**Our Case Number:** ABP-313509-22

**Re:** BusConnects Belfield/Blackrock to City Centre Core Bus Corridor Scheme  
Co. Dublin

Bus Connects  
UCD Ballsbridge to City Centre (Part of Belfield / Blackrock to City Centre Core Bus Corridor Scheme)  
Reference No. 313509  
Observations by Hilary and Rosemary Hough, 79 Nutley Lane

**TYPICAL SECTION V-V**  
**NUTLEY LANE**  
 LOCATED ON GA SHEET 22  
 DRAWING REF: BCIDC-ARP-GEO\_GA-1415\_XX\_01-DR-CR-0022

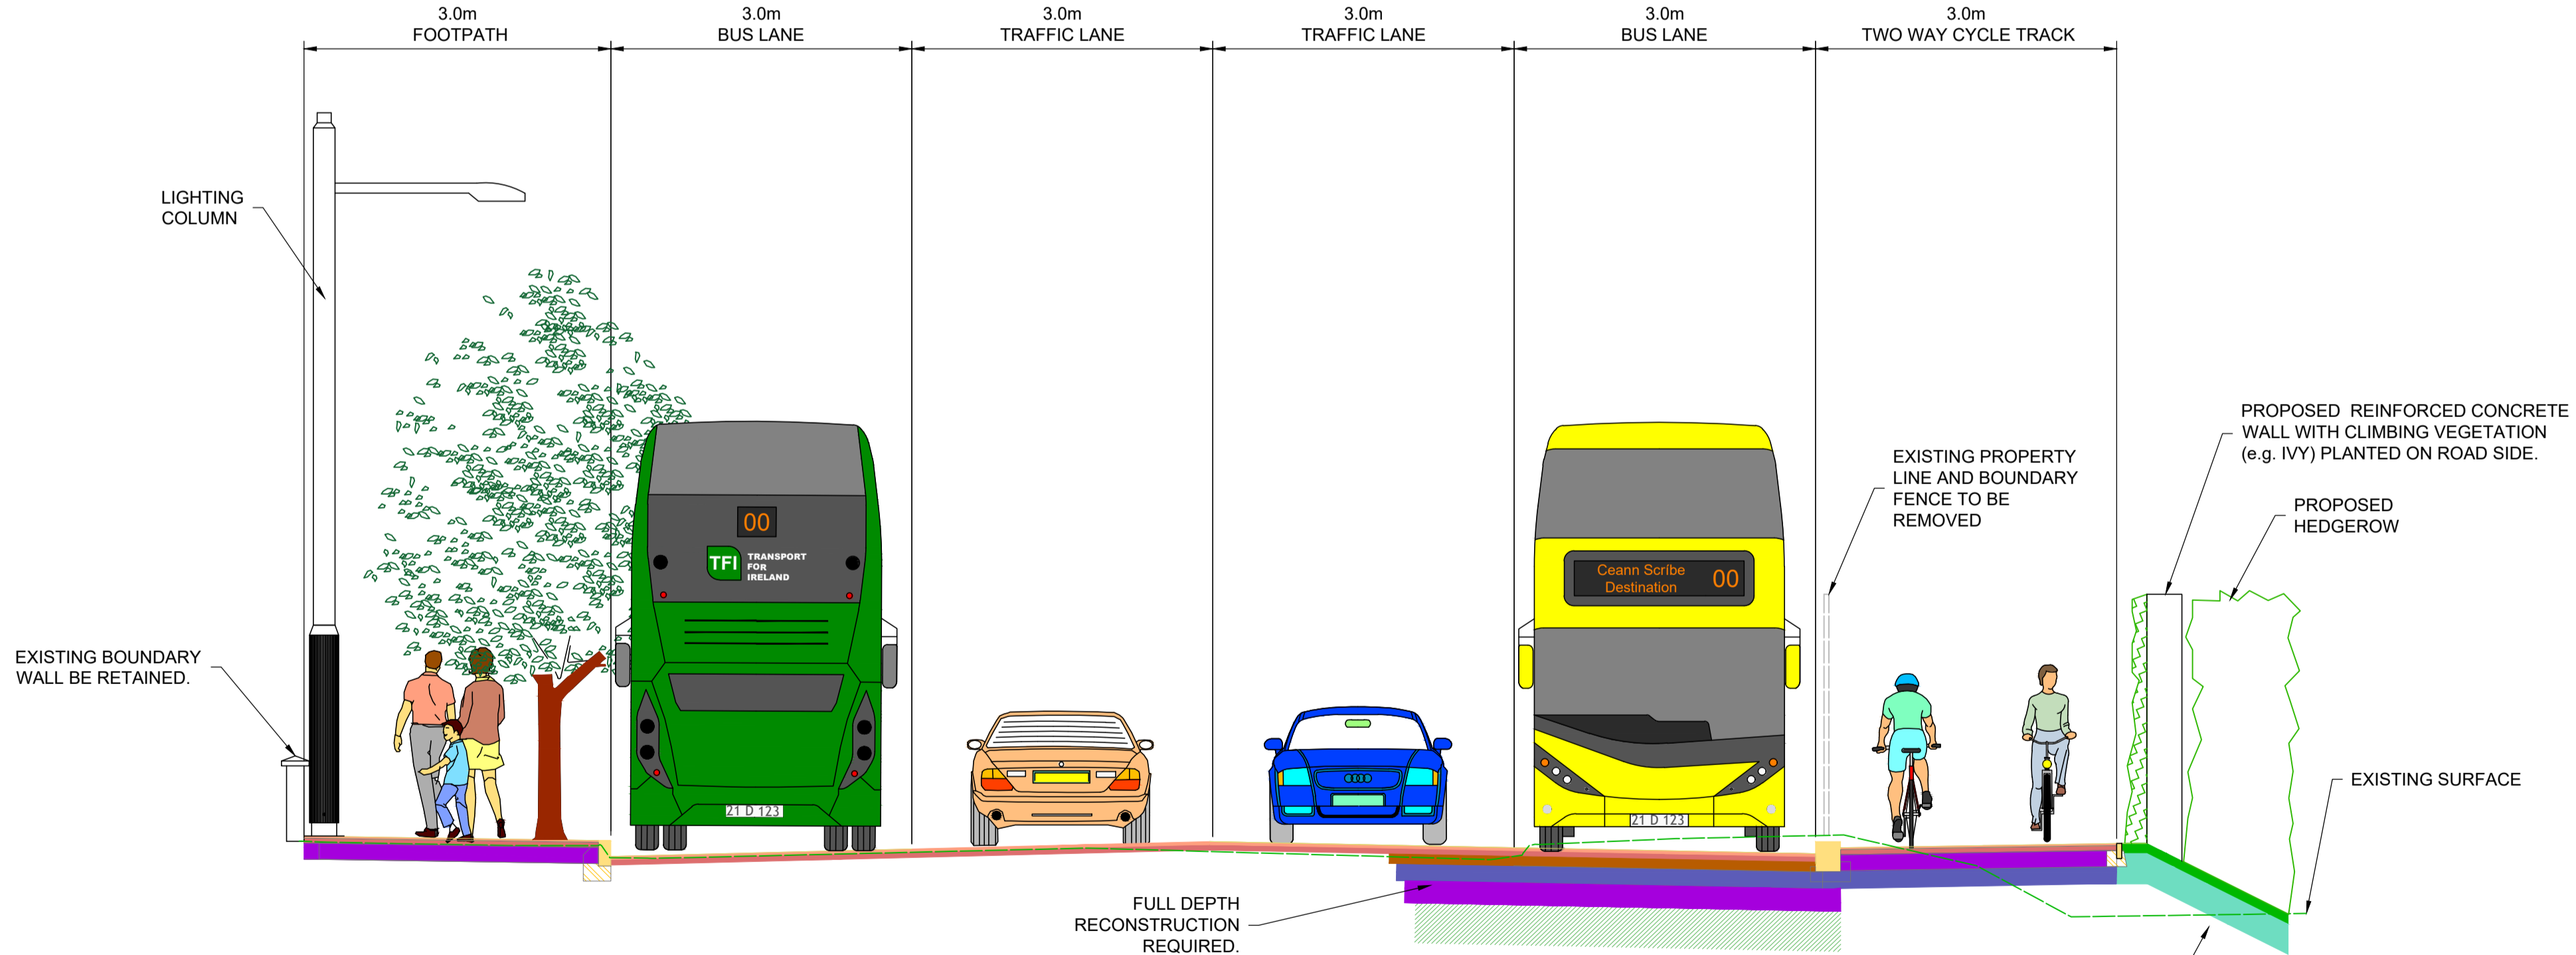
The reason why it ranks least well of the options is that it proposes four rather than three traffic lanes. This fourth lane is for the exclusive of cars which goes against the overall objectives of Bus Connects to reduce car usage and, ironically, it is this additional car lane which will lead to the destruction of the trees and hedges.

Nutley Lane currently has capacity to accommodate three vehicle lanes and one cycle lane. The inclusion of a fourth vehicle lane is to facilitate cars which goes against the overall objective of reducing the usage of cars and increasing usage of public transport. Additionally the inclusion of a fourth lane also has the greatest negative environmental impact both in terms of the destruction of trees and hedges and increased air and noise pollution resulting in a diminution of the quality of life of the residents and negatively impacting their physical and mental well being. As a result of the potential impact on the quality of life a number of residents on Nutley Lane have put their houses on the market but have been unable to find purchasers because of the Bus Connects proposals for Nutley Lane.

**Figure 3.67: Route Option NL2 Indicative Scheme Design**

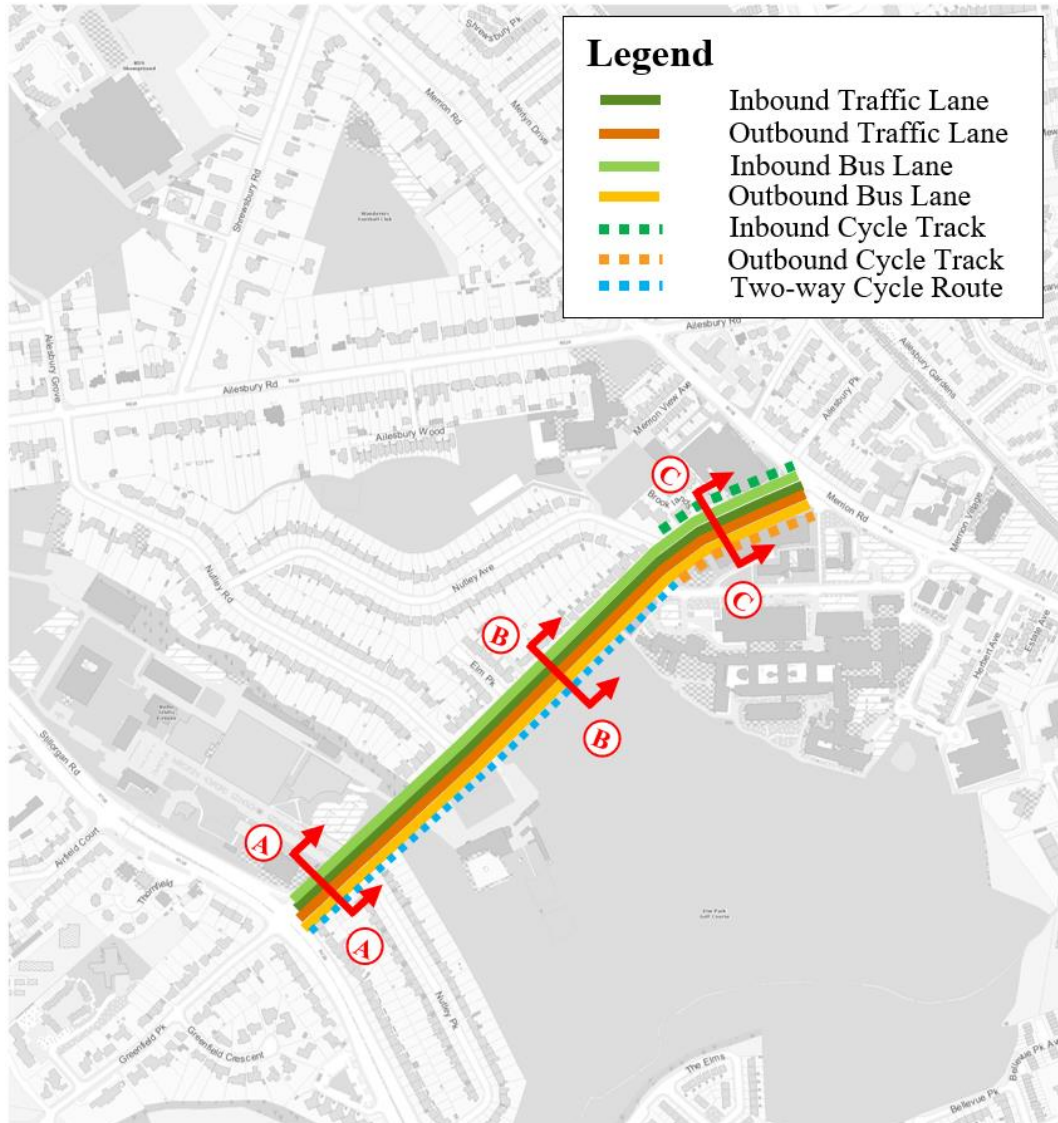
The NTA preferred option, Option NL2, involves the removal of c80 mature trees, many of which are up to 15mtrs high and some up to 100 years old, along the eastern boundary of Nutley Lane and the removal of 2 hedgerows, approx. 3mtrs high, along the boundary of the Elm Park Golf Club, to be replaced by a 'reinforced concrete wall with climbing vegetation (e.g. ivy) planted on the road side, and a hedgerow reinstated on the golf course side' and along the boundary of SVUH.

(A concrete wall would be totally inappropriate and should have been proposed to be of granite or other natural brick to minimise the visual and environmental impact on a residential area)

The preferred option Option NL2 ranks least well of six of the options reviewed by the NTA in terms of environmental impact.

**In the context of the Government's stated policy of protecting the natural environment and mitigating the impact of climate change it makes no sense that the chosen option is the one that does greatest damage to the natural environment and facilitates increased carbon emissions by providing an additional dedicated car lane.**

**Figure 3.72: Route Option NL3 Indicative Scheme Design**

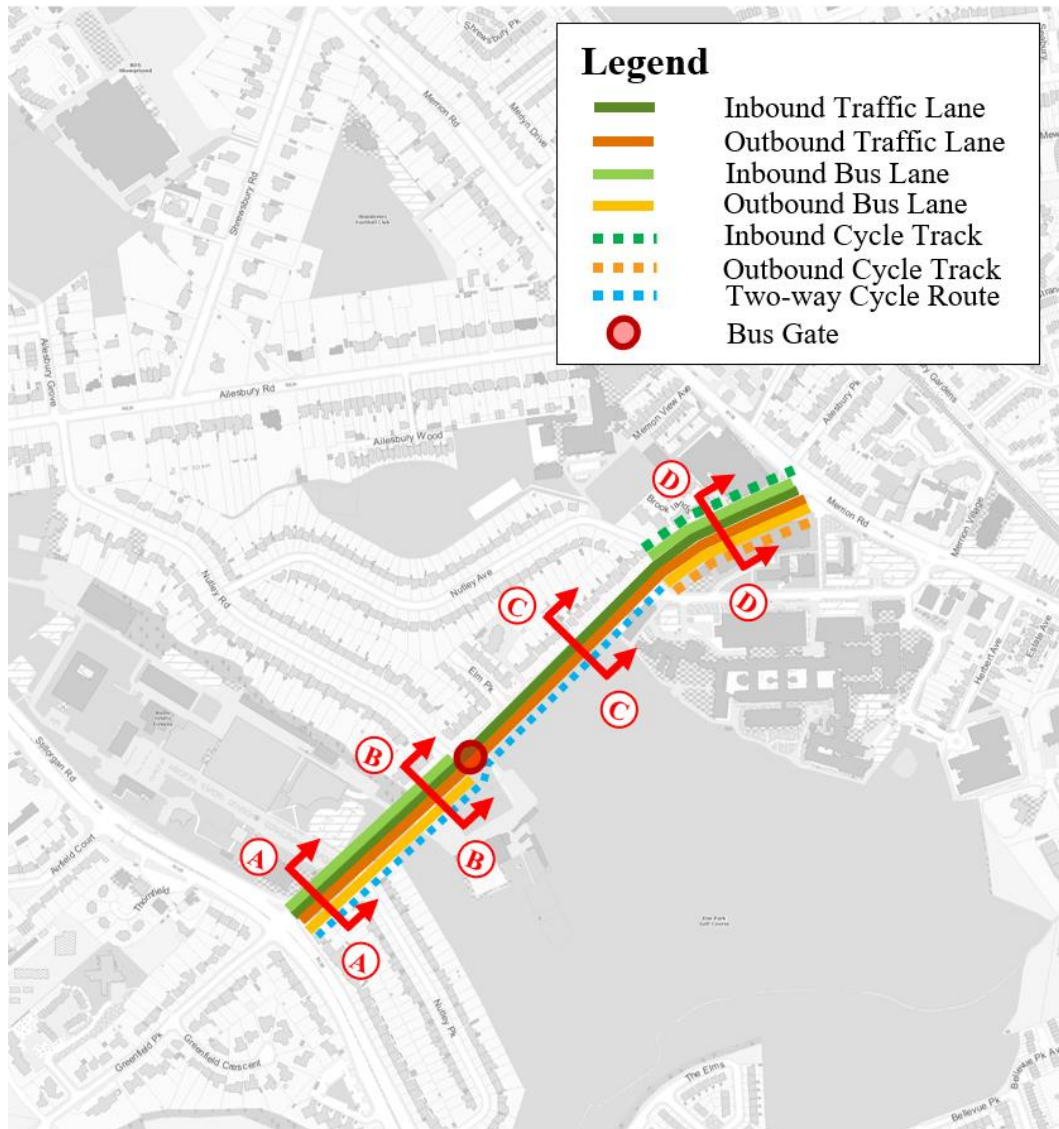
#### **1. Adopting Option NL3**

*"Option NL3: As per NL2 from the R138 Stillorgan Road to Nutley Road and from St. Vincent's University Hospital entrance to the R118 Merrion Road, however, reduced to only two general traffic lanes between Nutley Road and St. Vincent's University Hospital entrance;  
This arrangement would be facilitated through the introduction of a Bus Gate on the northern side the Nutley Road junction"*

These options were rejected by the NTA primarily because they contended that they would have a greater impact on bus reliability and timing than the preferred option

We would challenge this rationale for rejection of the options on the following basis:

- The NTA preferred option envisages two traffic light controlled junctions and two toucan crossings on the 700mtr length of Nutley Lane. The impact of these on bus timing reliability would be similar to the impact of the proposals in the rejected options.

**Figure 3.75: Route Option NL4 Indicative Scheme Design**

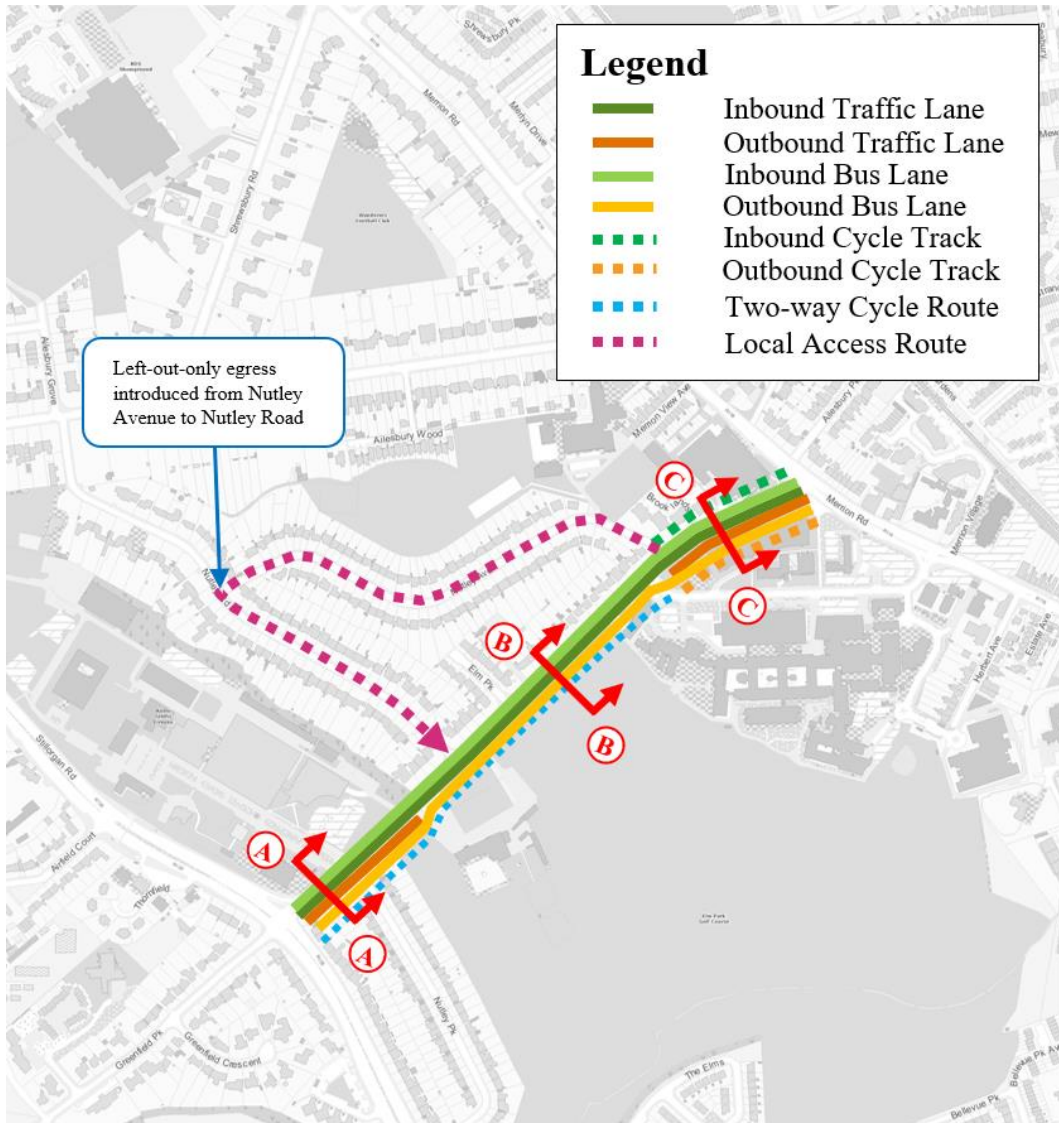
#### **2. Adopting Option NL4**

*"Option NL4: As per NL2 from the R138 Stillorgan Road to Elm Park Golf & Sports Club entrance and from St. Vincent's University Hospital entrance to the R118 Merrion Road, however, reduced to a single one-way northbound general traffic lane between Nutley Road and St. Vincent's University Hospital entrance – with potential for offline traffic management measures. A continuous bus lane is proposed in either direction"*
